**Consultation Response from KC,
Highways Development Management**

2024/92779 land at Providence Street, Earlsheaton, Dewsbury, WF12 8HZ

Outline application for residential development

Date Responded: 9-6-2025.

30 TOWN STREET/SYKE LANE SUBJECT TO 30MPH SPEED LIMIT

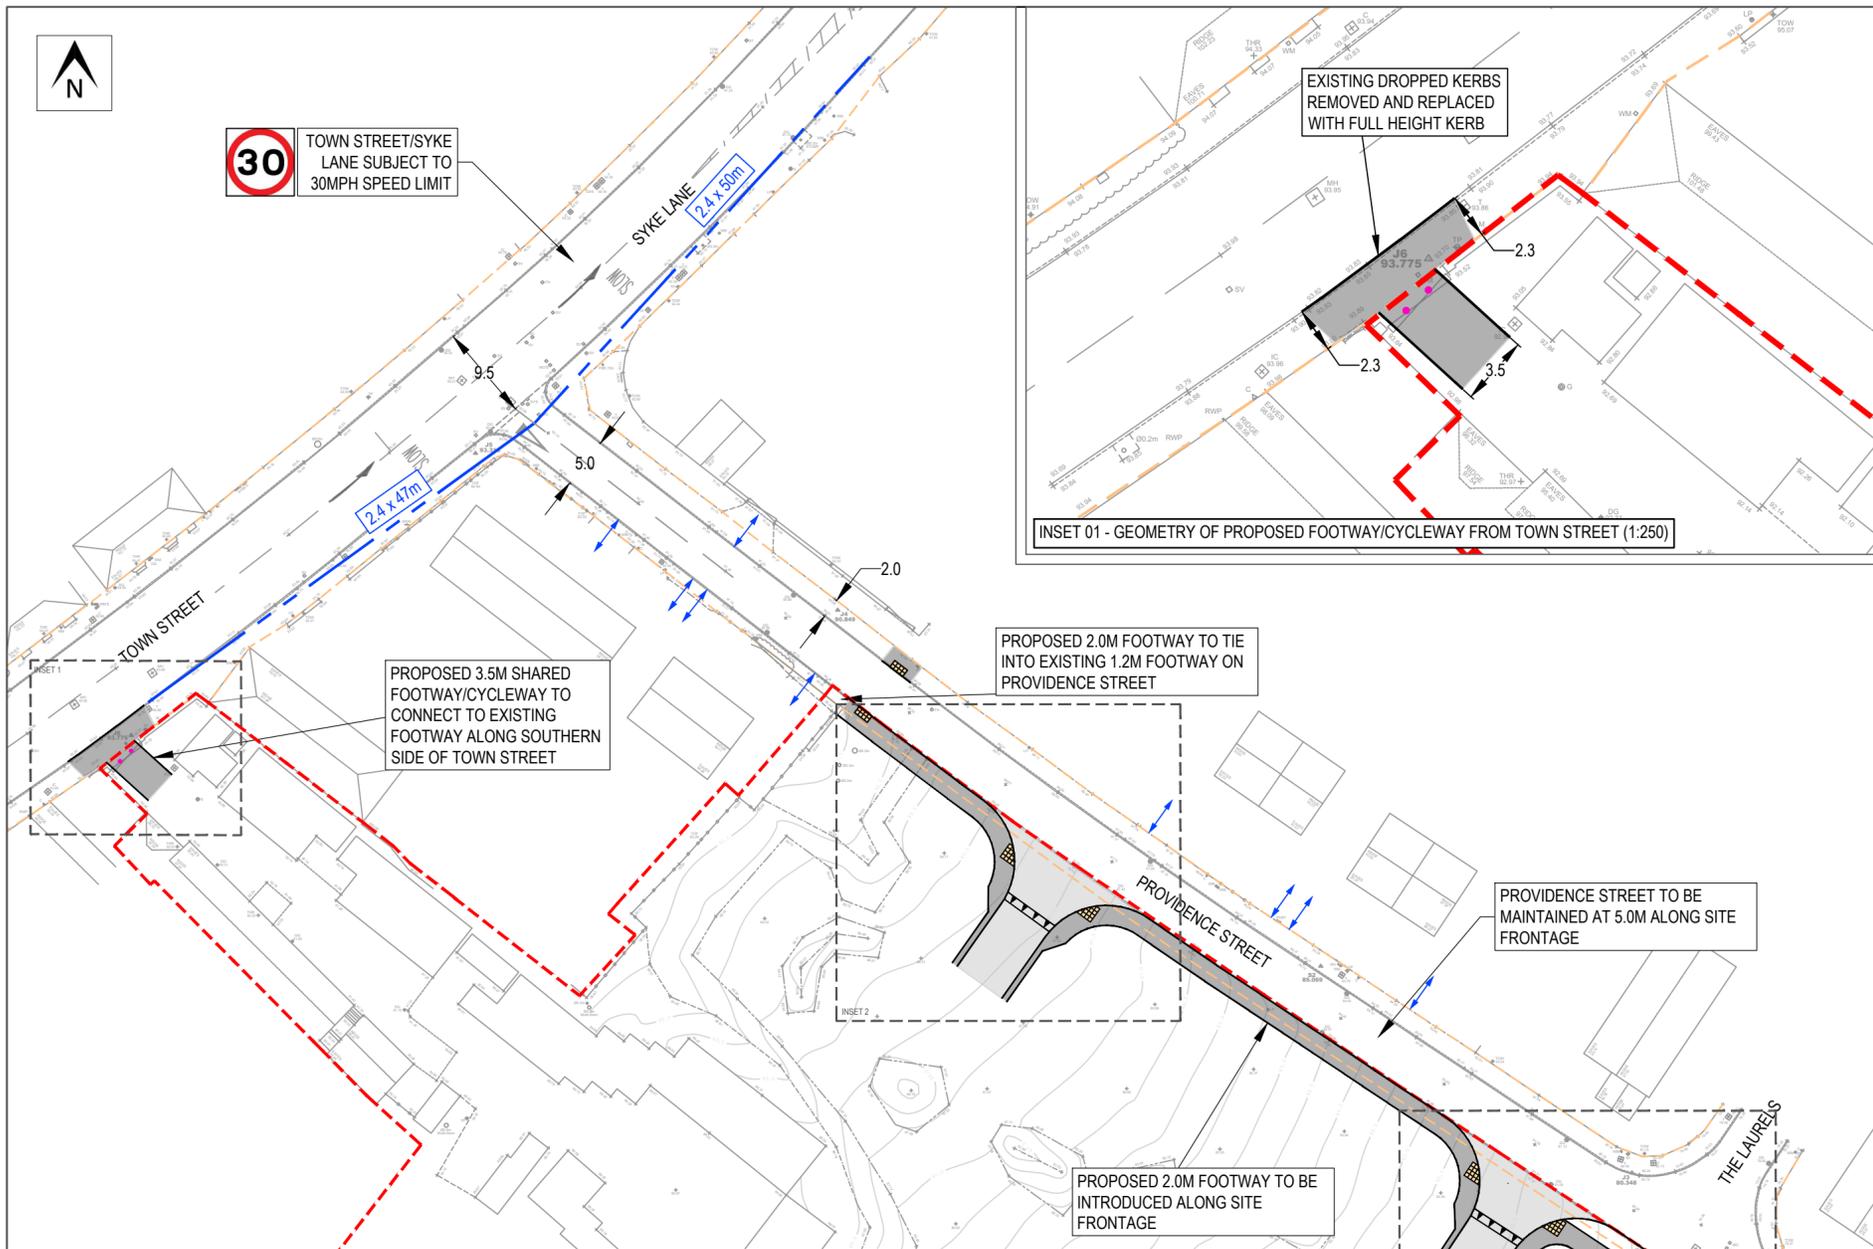
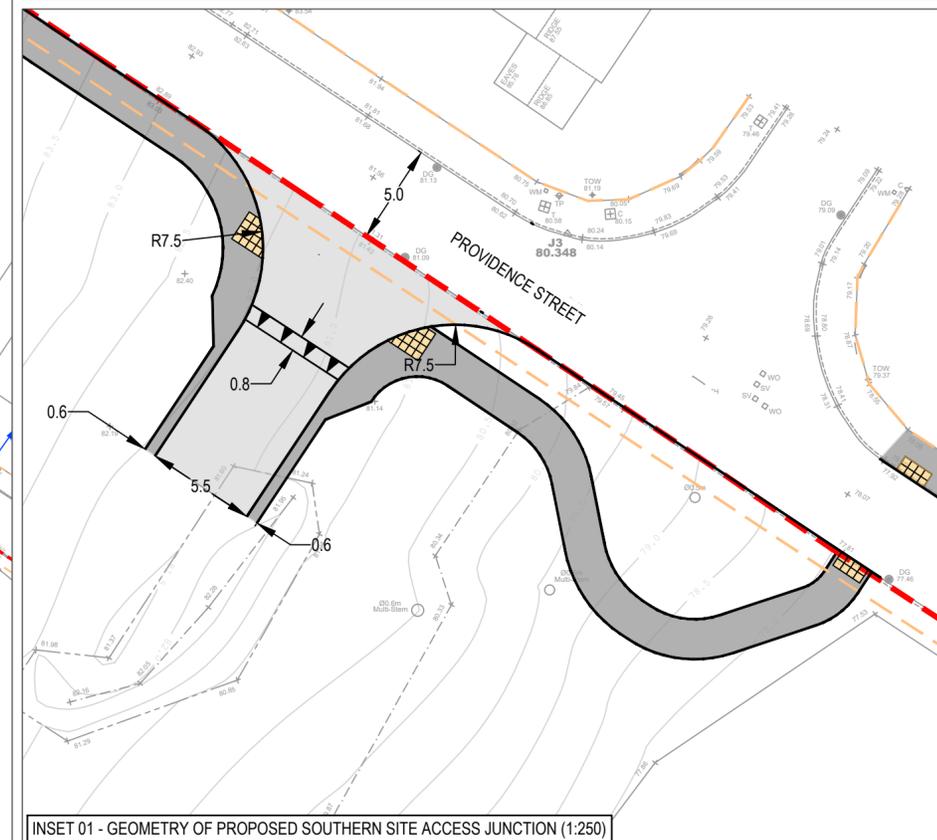
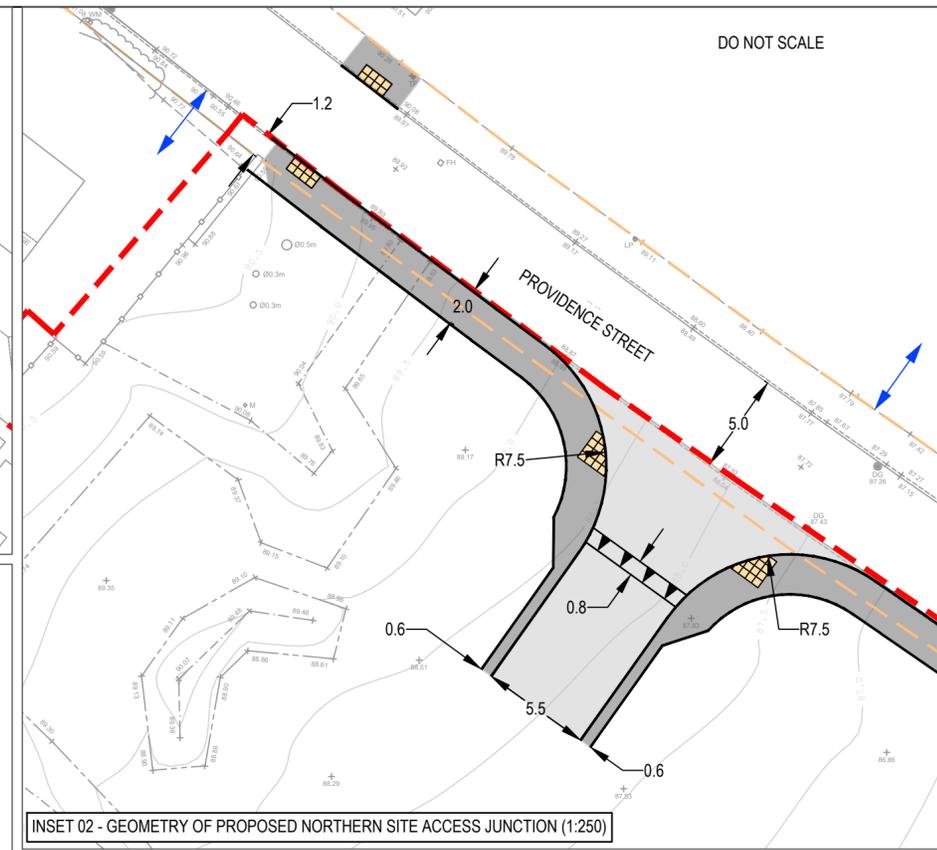
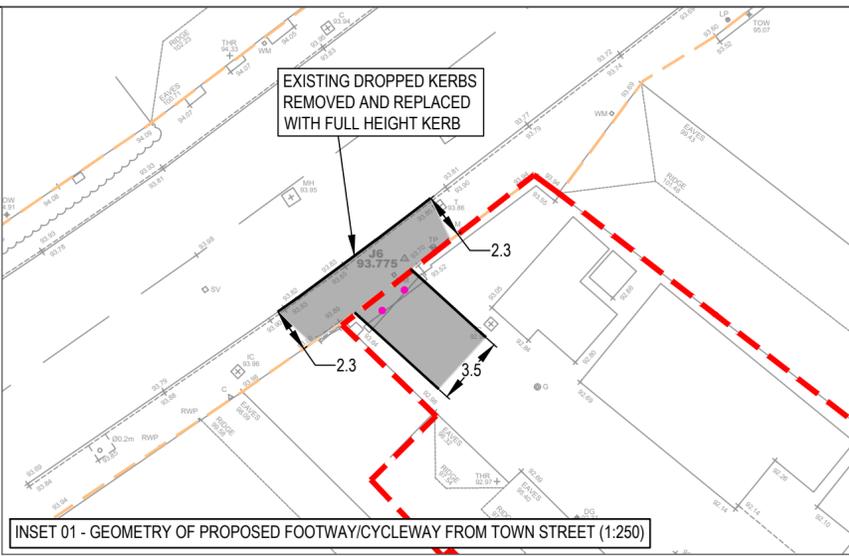
Unfortunately, the swept path drawing does not provide any movements from the south-eastern side and given that Providence Street is not a one-way street, and we need to consider the other approach also.

Please ask the applicants to provide swept paths that show all vehicle movements at the junctions.
